DRB Application No.: 05DRB-01050

Project Name: EAGLE RANCH SUBDIVISION

**CITY OF ALBUQUERQUE, PLANNING DEPARTMENT
INTERNAL MEMORANDUM**

RE: **PROJECT NO. 1003763, Case Number 05DRB – 01050, Ameri – Contractors Bldg, Eagle Ranch & Paradise.**

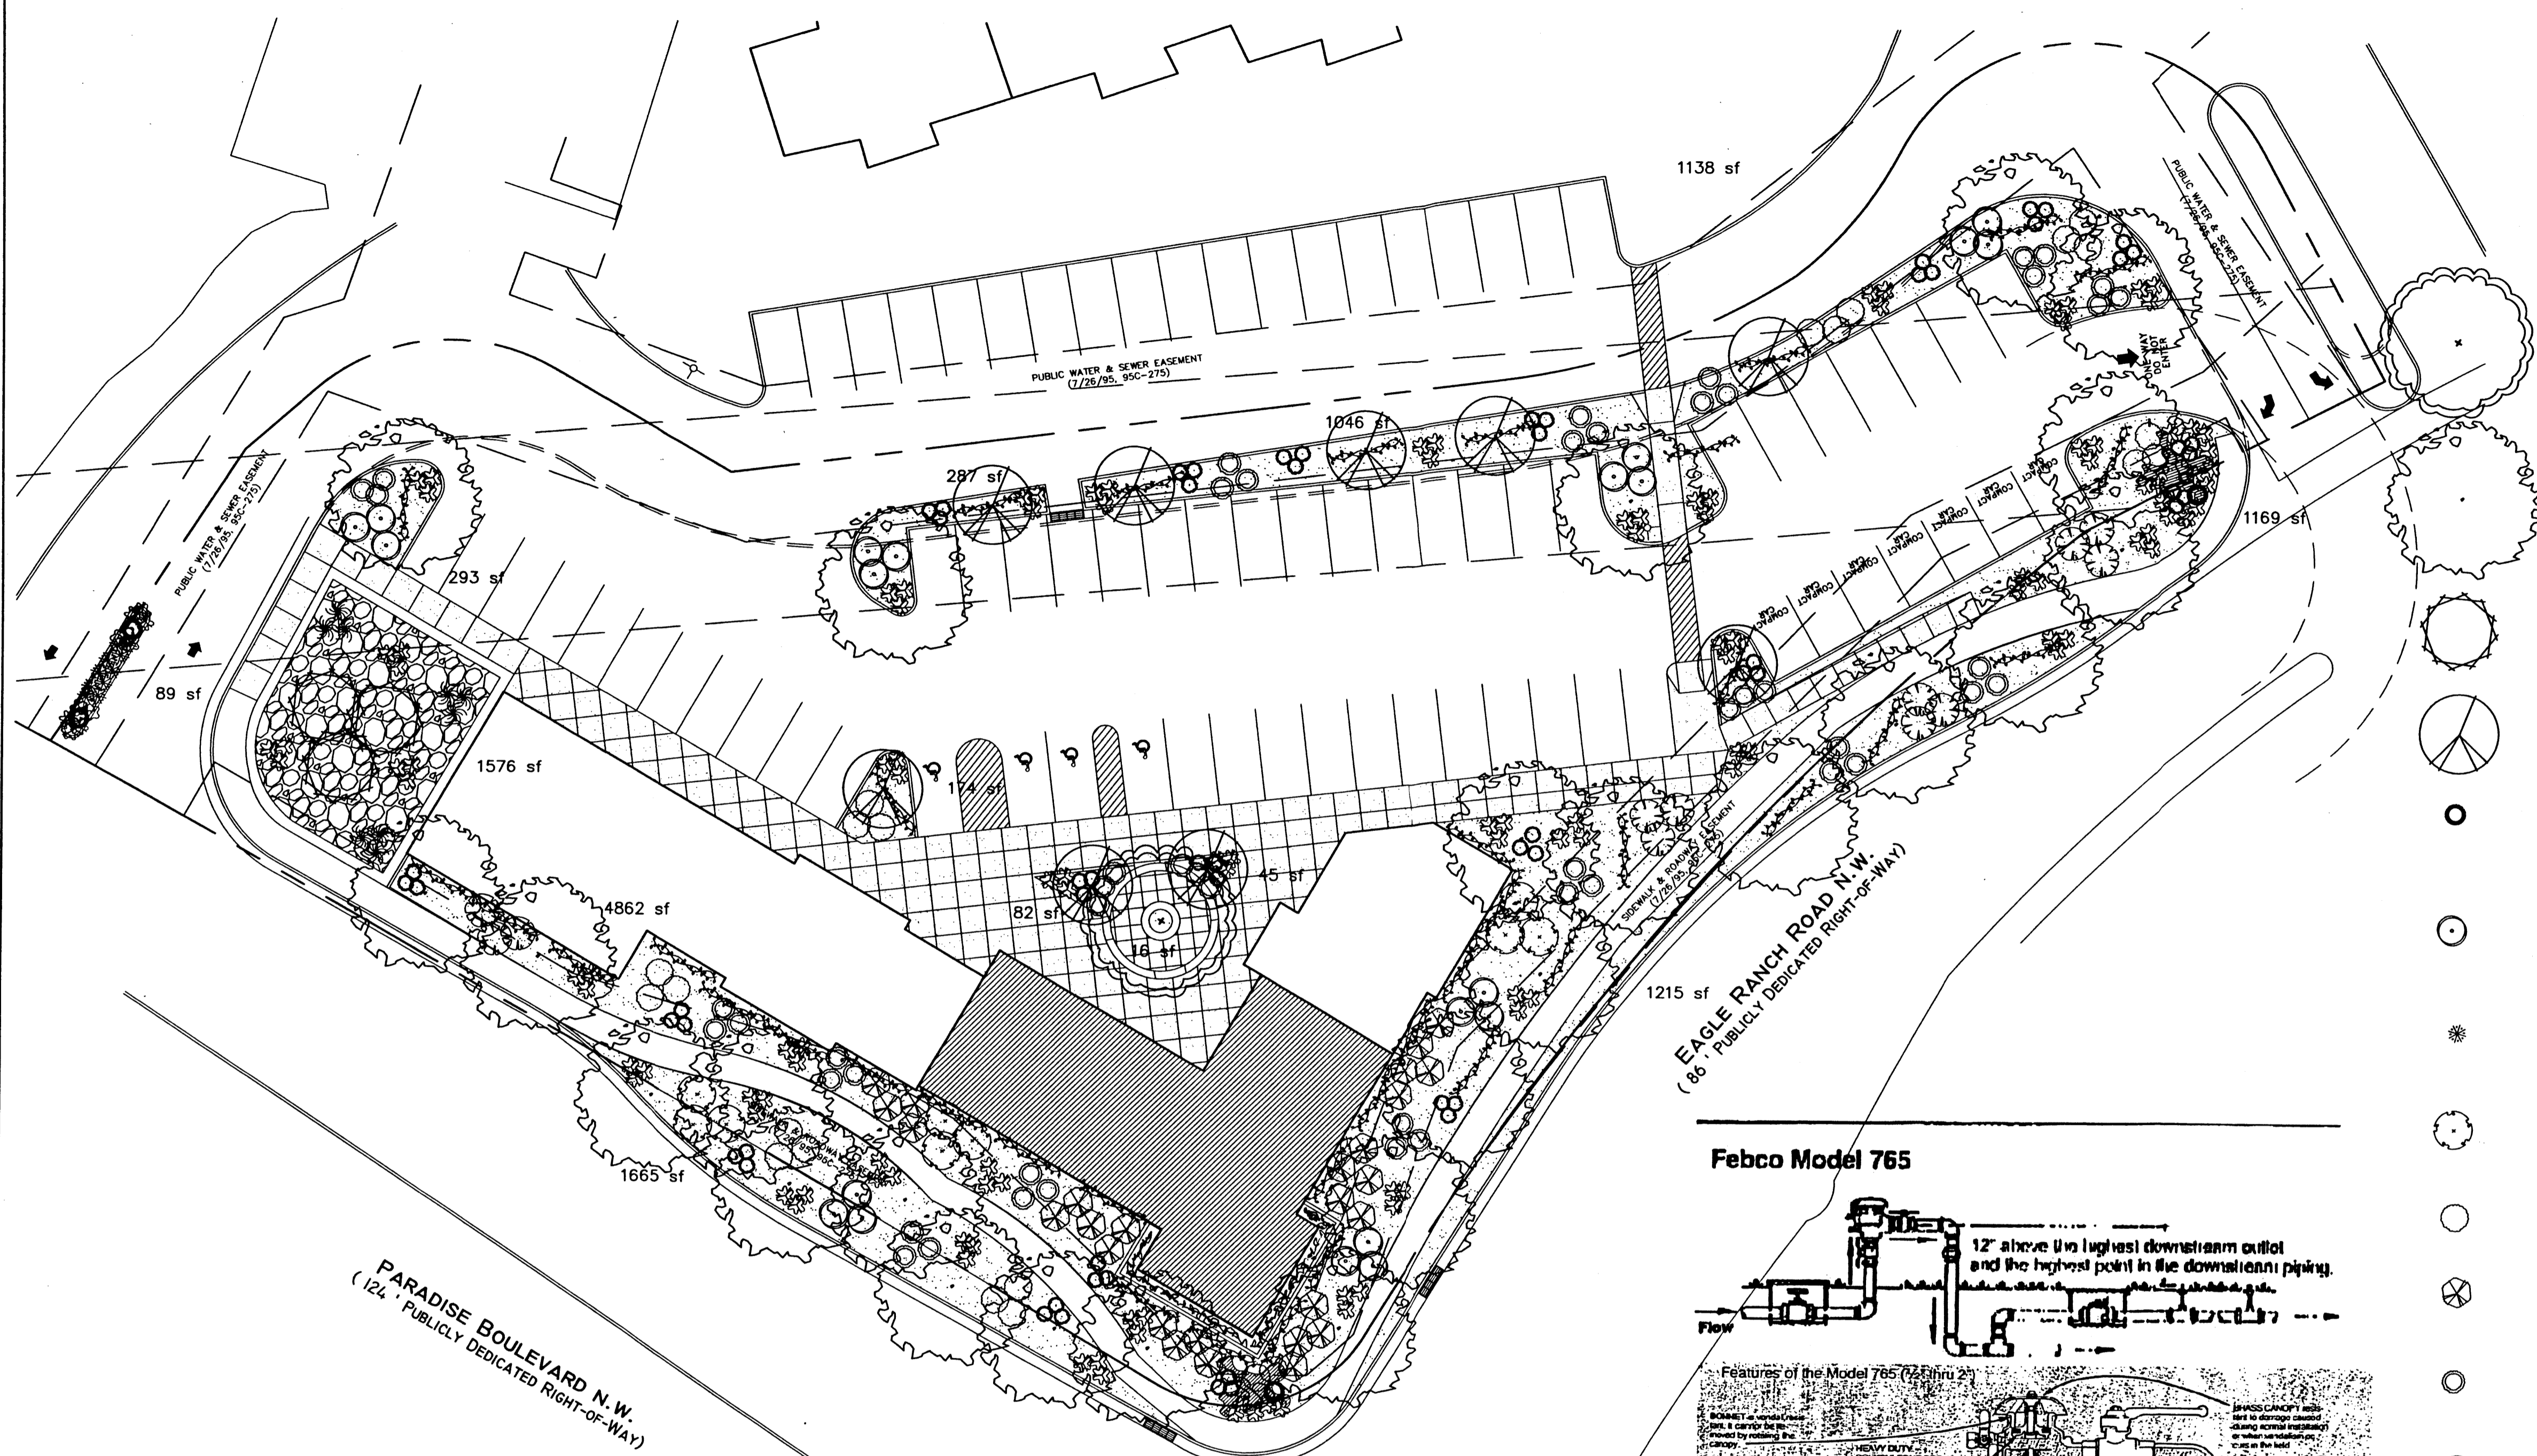
7. *On-site lighting shall be shielded to provide downward light emission and prevent both light trespass and upward light pollution. This condition has not been satisfactorily demonstrated on the site plan.*

Miscellaneous Comments: Are the sidewalks extending into the project area from either Eagle Ranch or Paradise ADA-compliant? I noticed that they do not appear to go any further beyond the property curve return. This needs to be checked with Engineering.

**GRADING AND DRAINAGE PLAN**

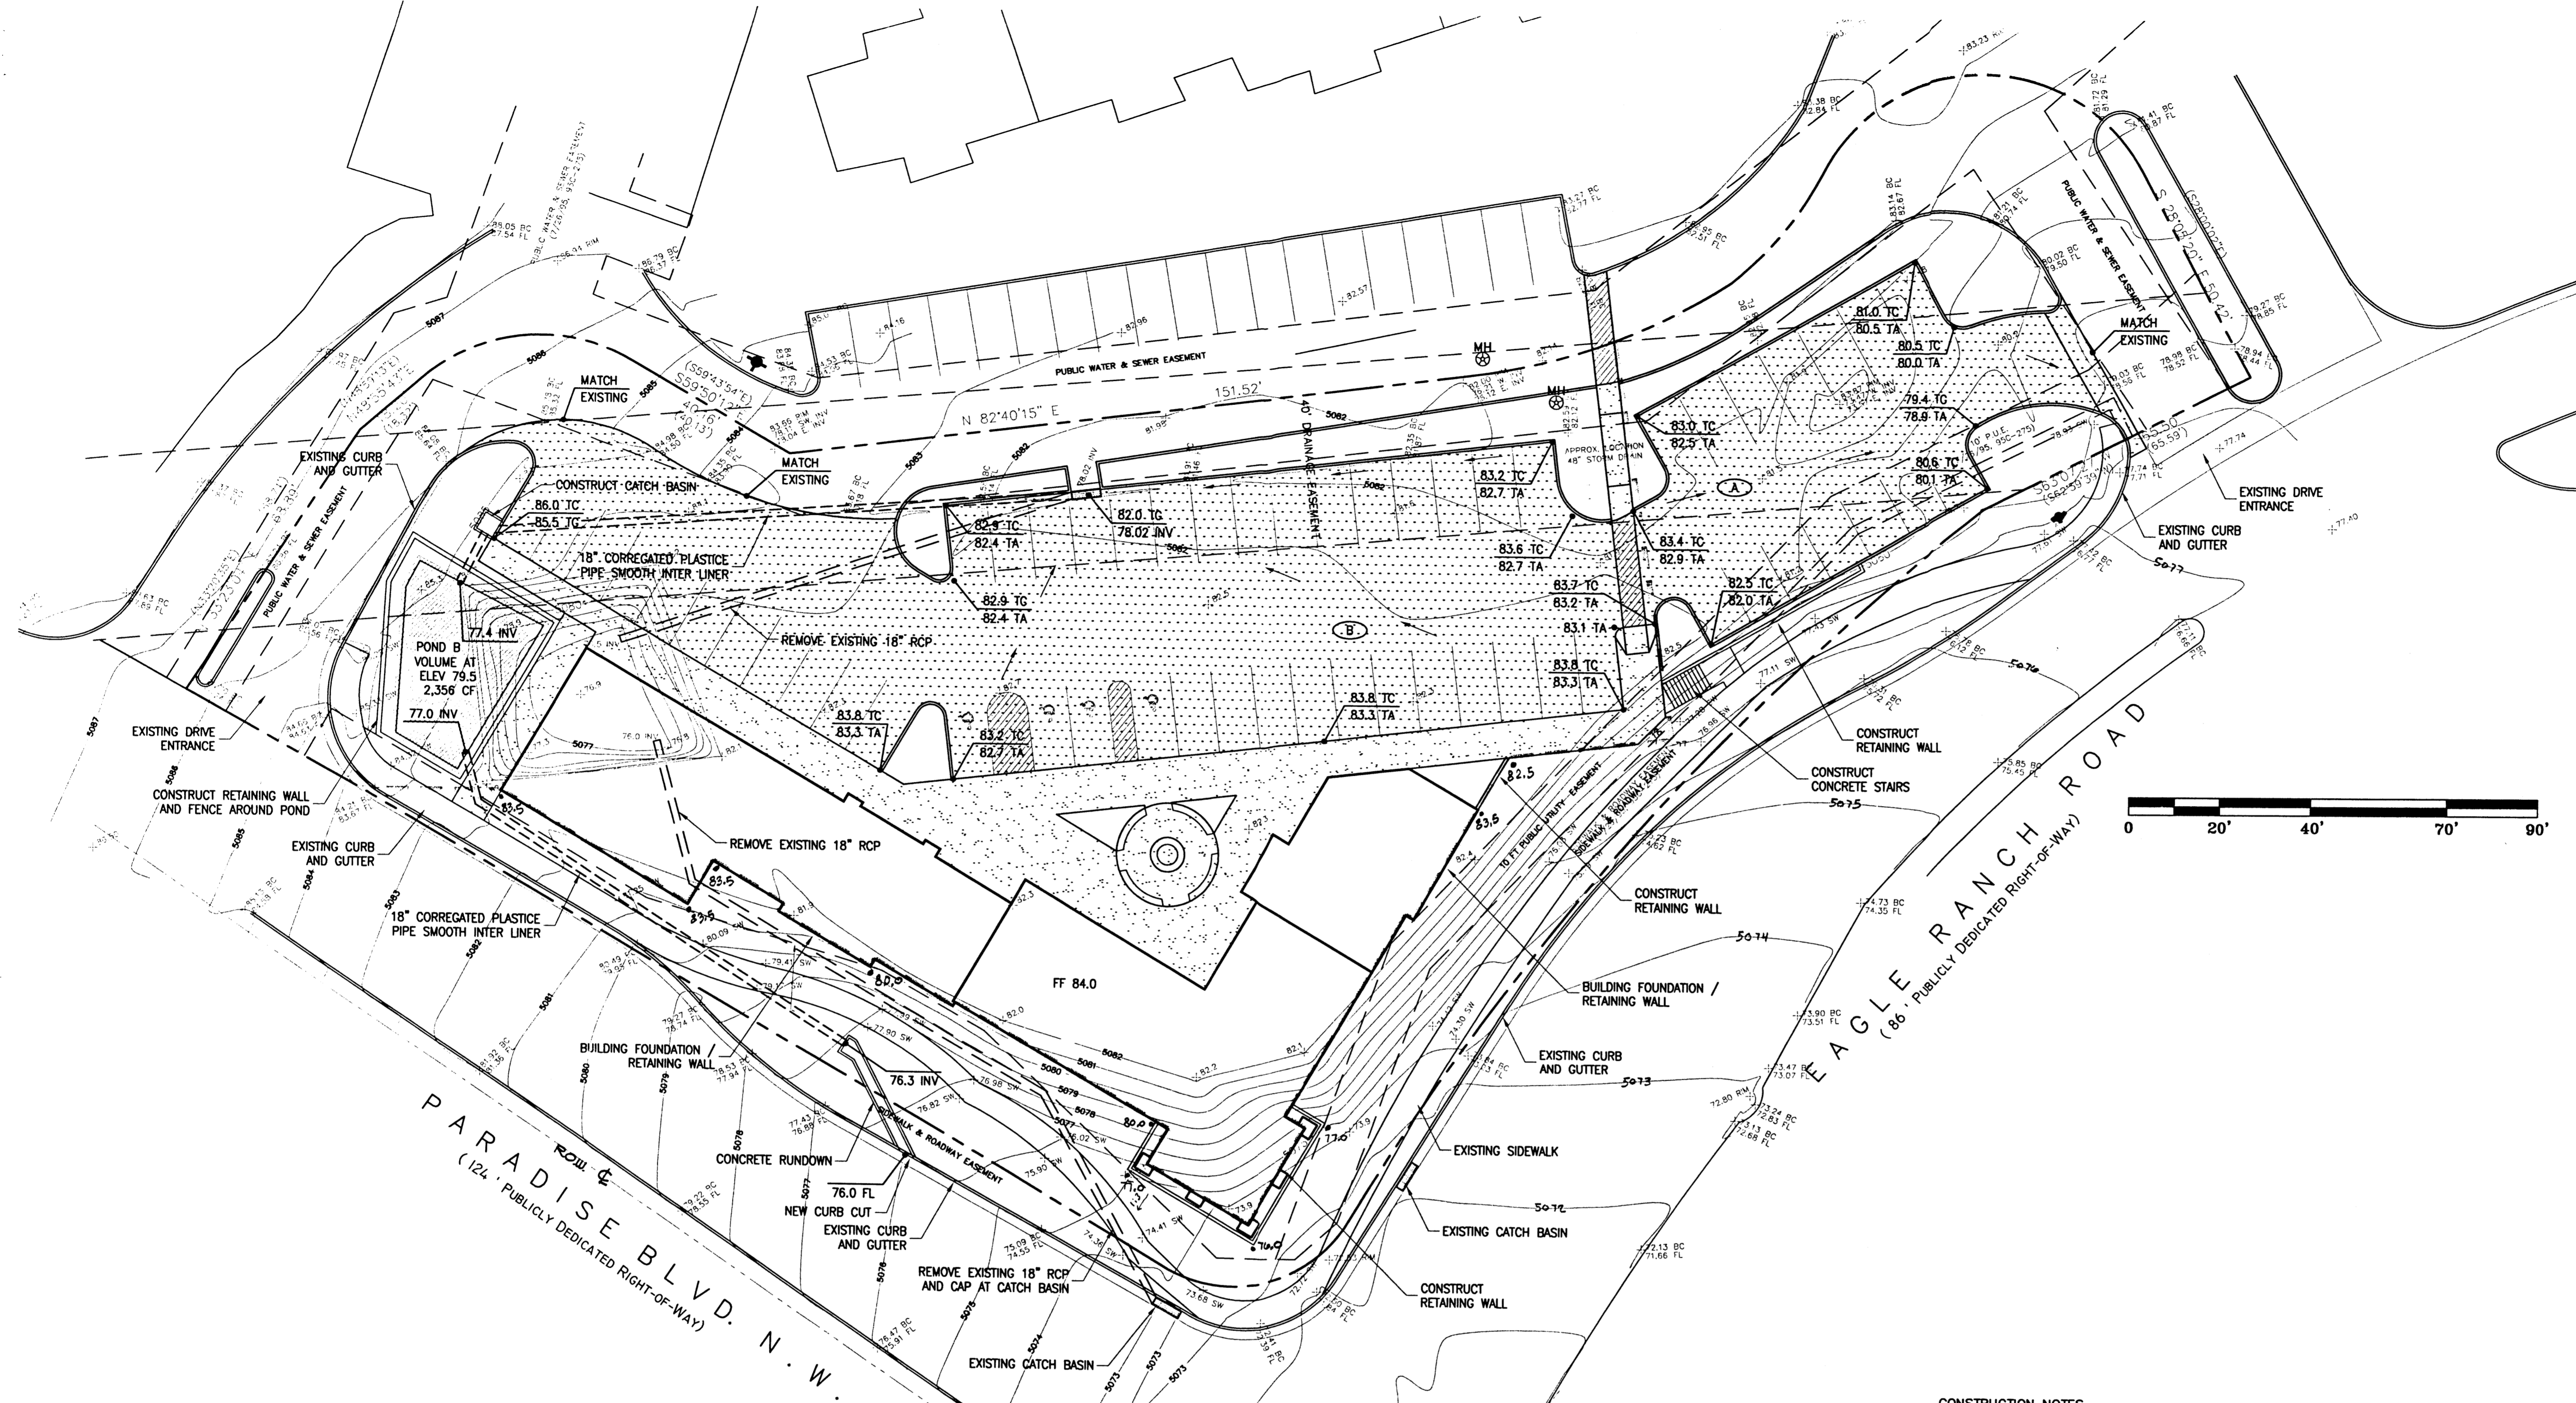
10. *Façade treatments and articulation of any proposed retaining walls will comply with §14-16-3-19 of the Zoning Code and shall be properly demonstrated prior to final plan approval. This condition has not been satisfactorily demonstrated on either the site plan or the grading/drainage plan.*

11. *Vegetative cover, such as vines or vegetated trellises, will be placed on any proposed retaining walls. A proportionate amount of evergreen trees or appropriate cover will be included alongside any retaining walls to break up the massing. This condition has not been satisfactorily demonstrated on either the site plan or the landscape plan. There is not enough emphasis on evergreen trees or covering around those areas where retaining walls along public streets are called out, and there is no indication that trellising, where applicable, is utilized.*
